Online Comment

Application H16-0042-26
Location THE CHANTRY 7 CHURCH STREET SPALDING PE11 2PB
Proposal Works to include replacement windows and doors, repointing, new clay chimney pot and removal of internal wall between kitchen and dining room above counter level only

Name Ruben Lopez Catalan
Address Lincolnshire County Council, County Offices, Newland, Lincoln LN1 1YL
LN1 1YL

Date Submitted 03-02-26
For/Against Comments

P1	19.01.26	Listed Building Application	RCW
Ref.	Date	Description	Initial

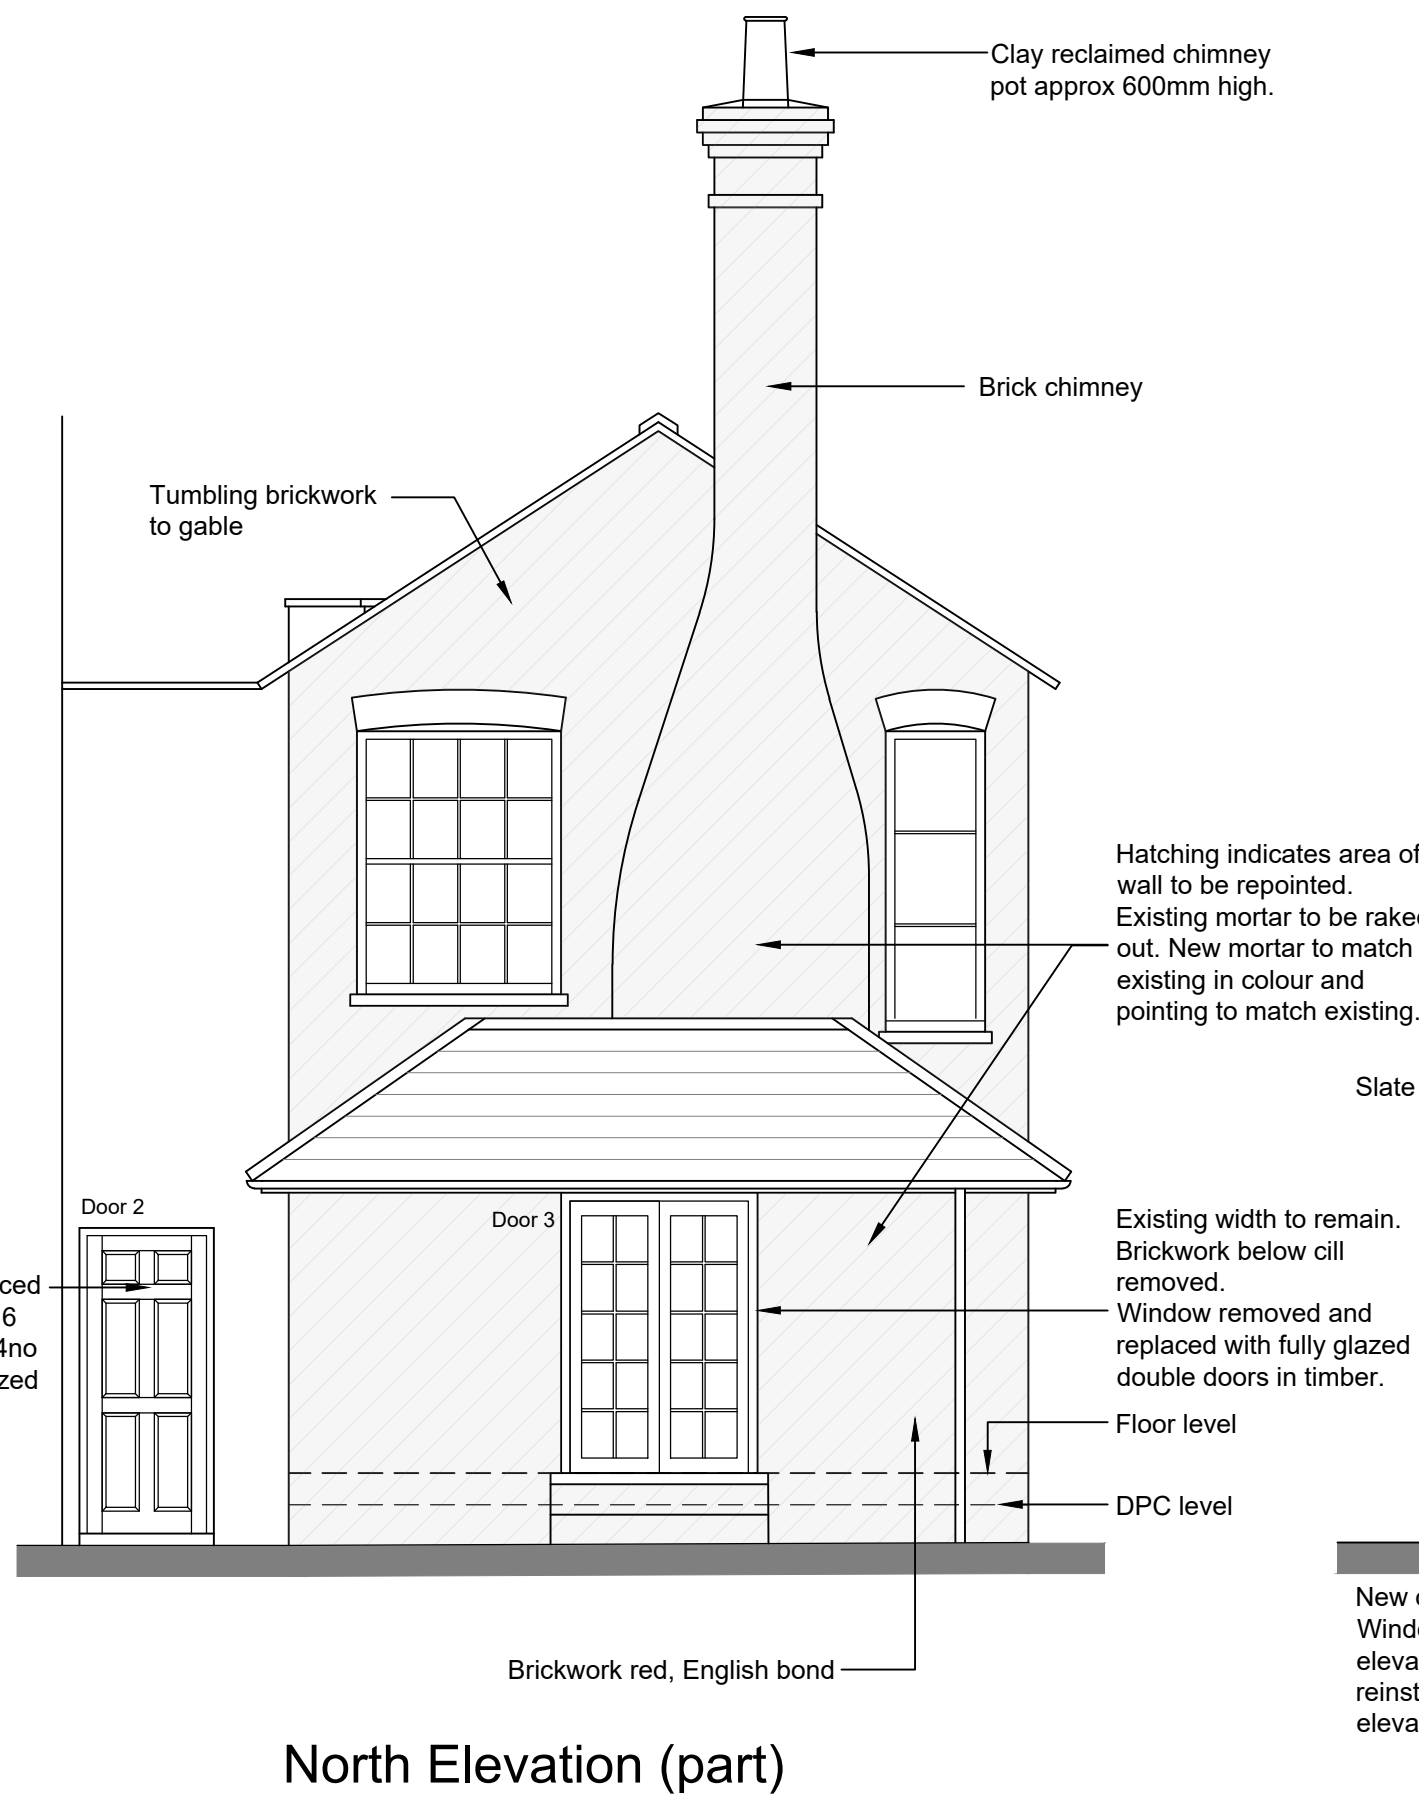
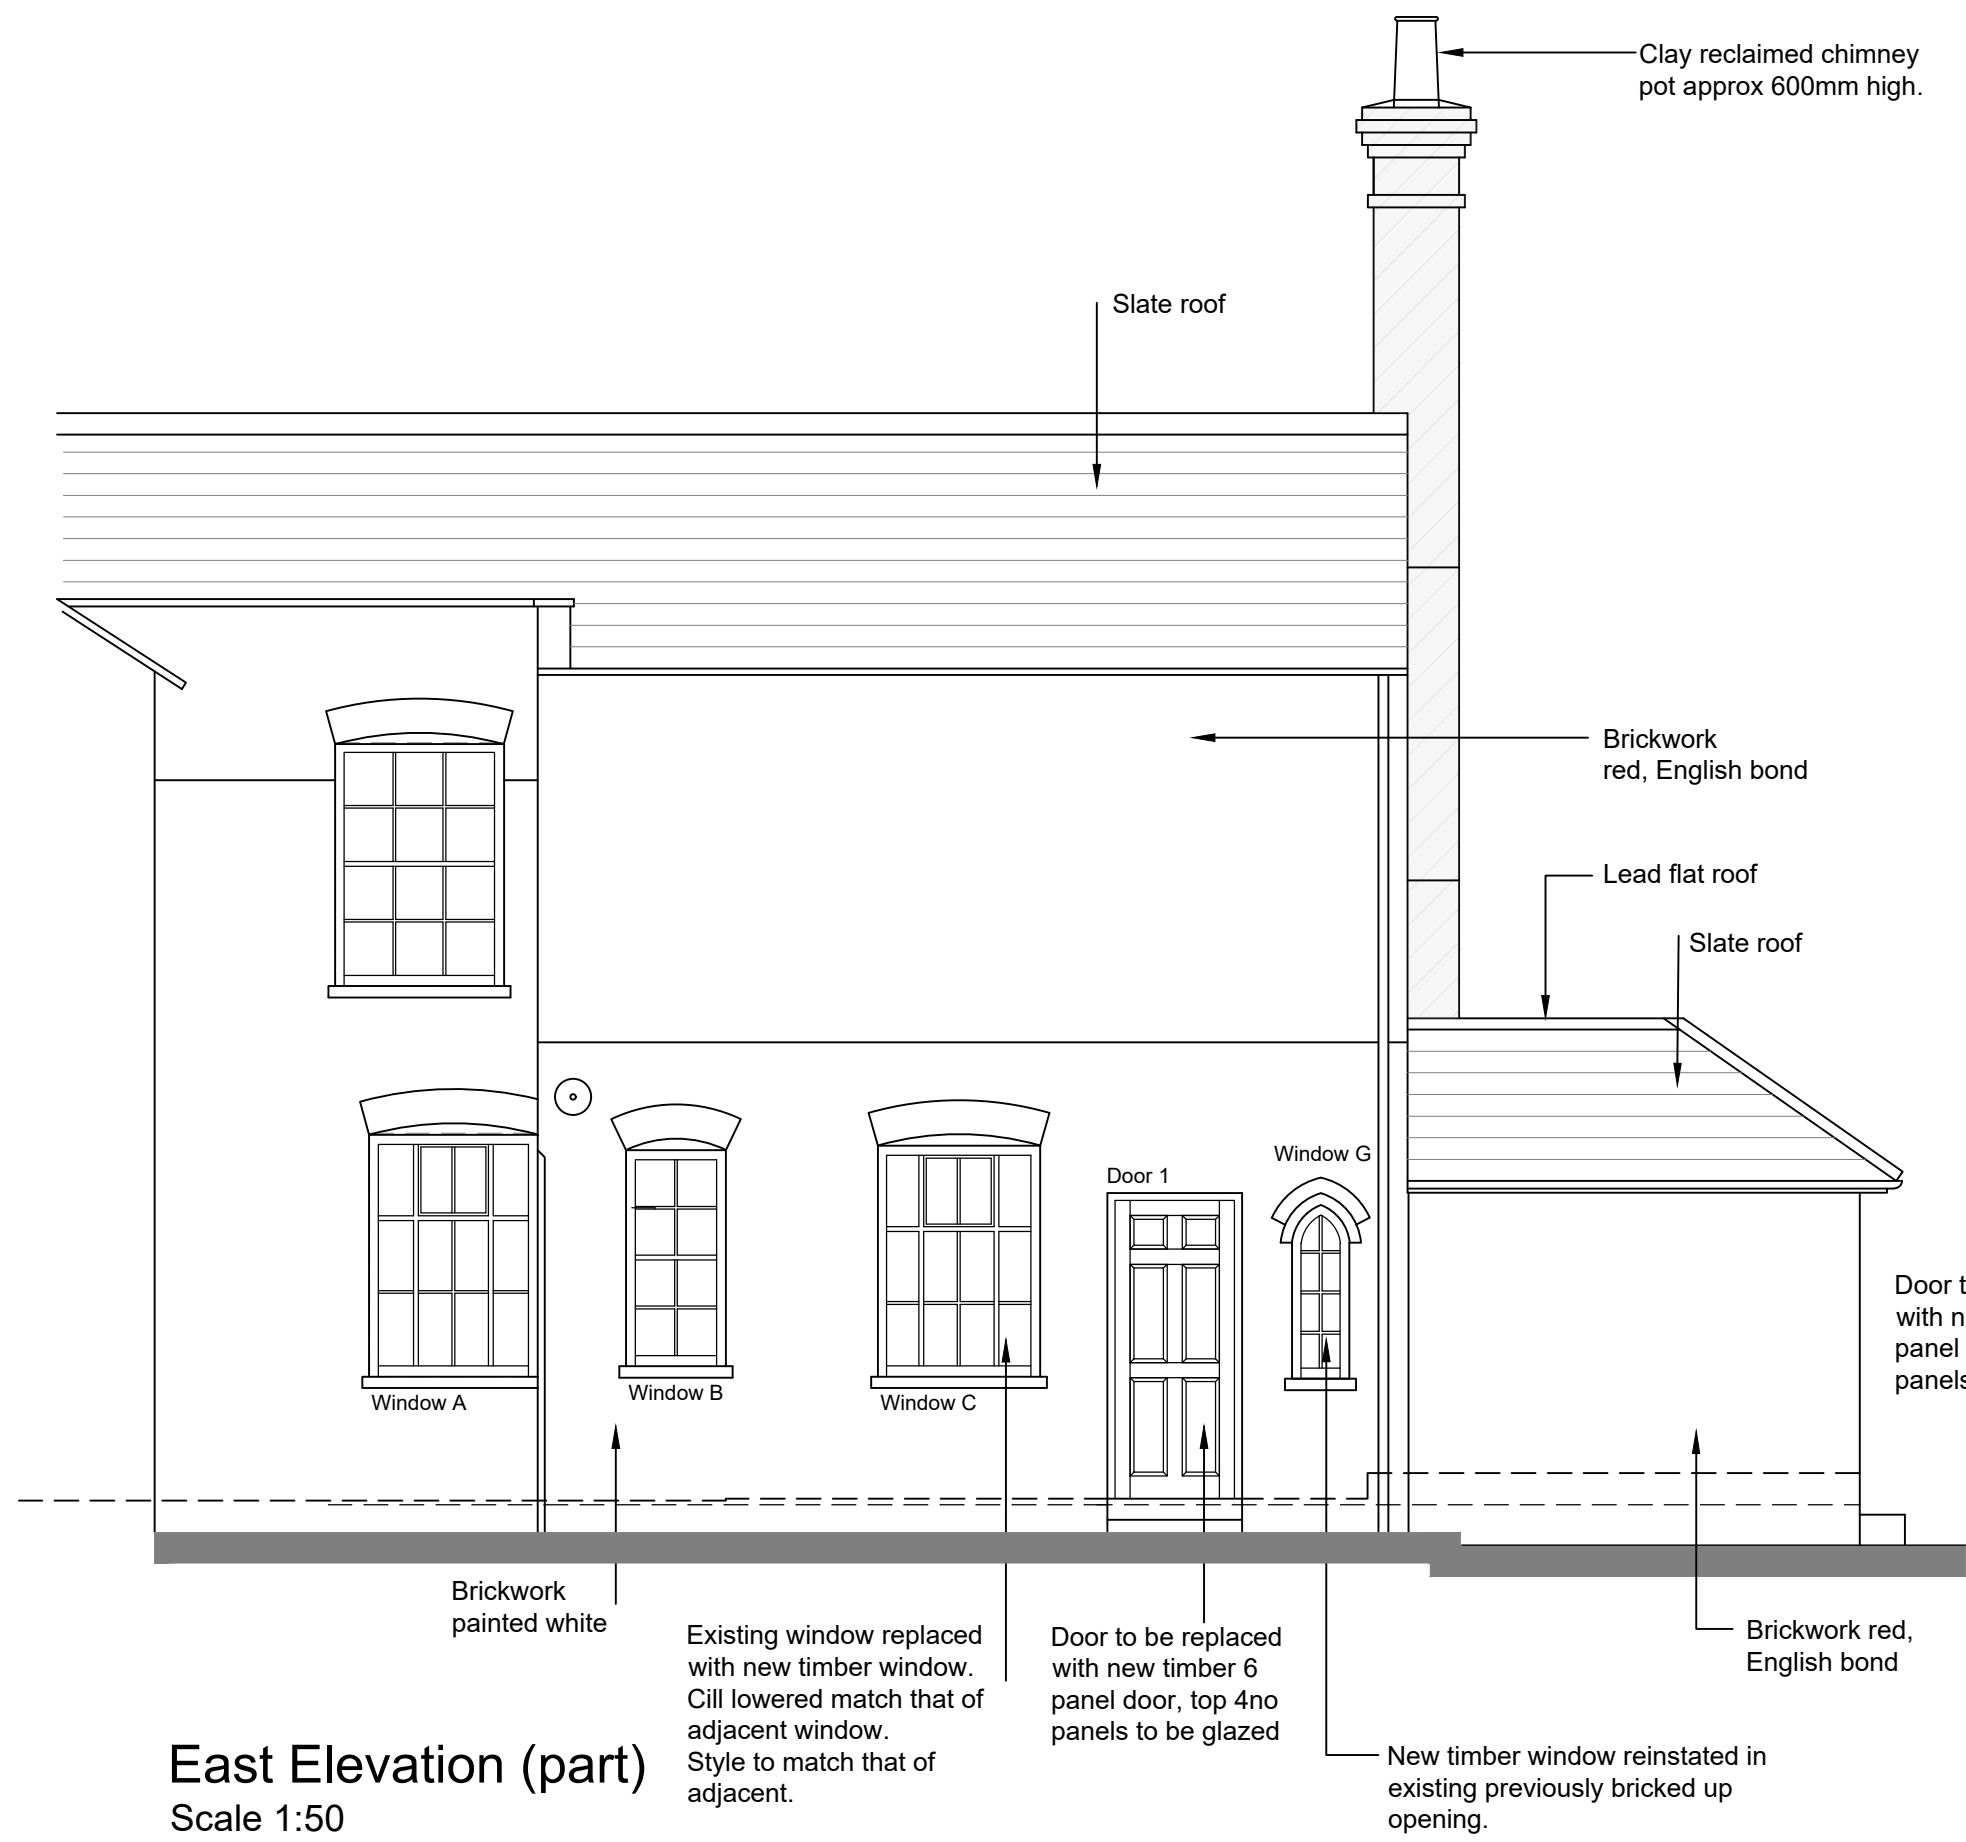
This will comprise a programme of pre-development mitigation works, including a Level 1 historic building recording of the HIA identified items 1, 5 and 6 (1. Partial removal of the internal wall between the kitchen and dining area; 5. Replacement of Window D with Door; and 6. Relocation of Window), to be undertaken in accordance with Historic England's Understanding Historic Buildings: A Guide to Good Recording Practice (2016).

We recommend that, if permission is granted, a condition be attached requiring a mitigation strategy to effectively address this site.
